MEMORANDUM

To: FILE
From: Jean Fraser
Subject: Application ID: 2017-103
Date: 7/6/2017

Comments Submitted by: Keith Gautreau/Fire on 7/6/2017

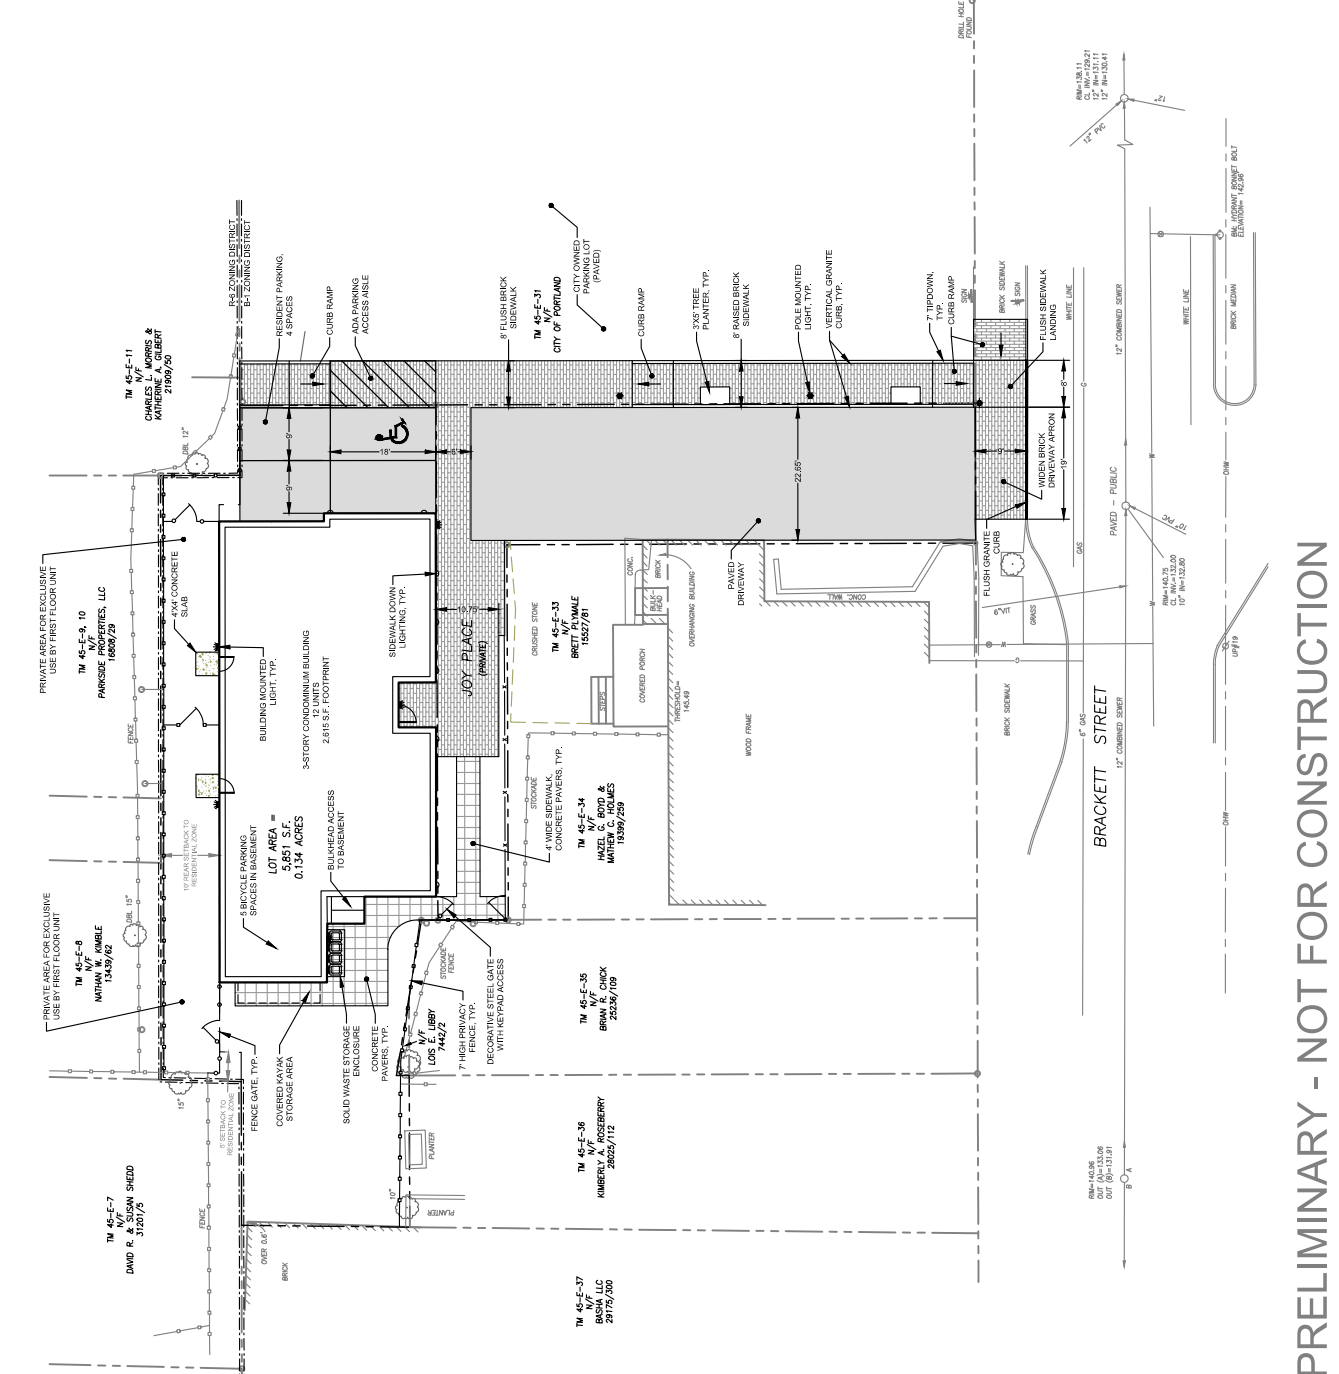
I have read the email sent from the applicant about the background on the emergency access and parking. The Fire Dept. would like to see some signage in terms of "No Parking Fire Lane" in addition to the language in the deed. We feel it would be necessary in helping maintain the only access to the proposed 12 unit building.
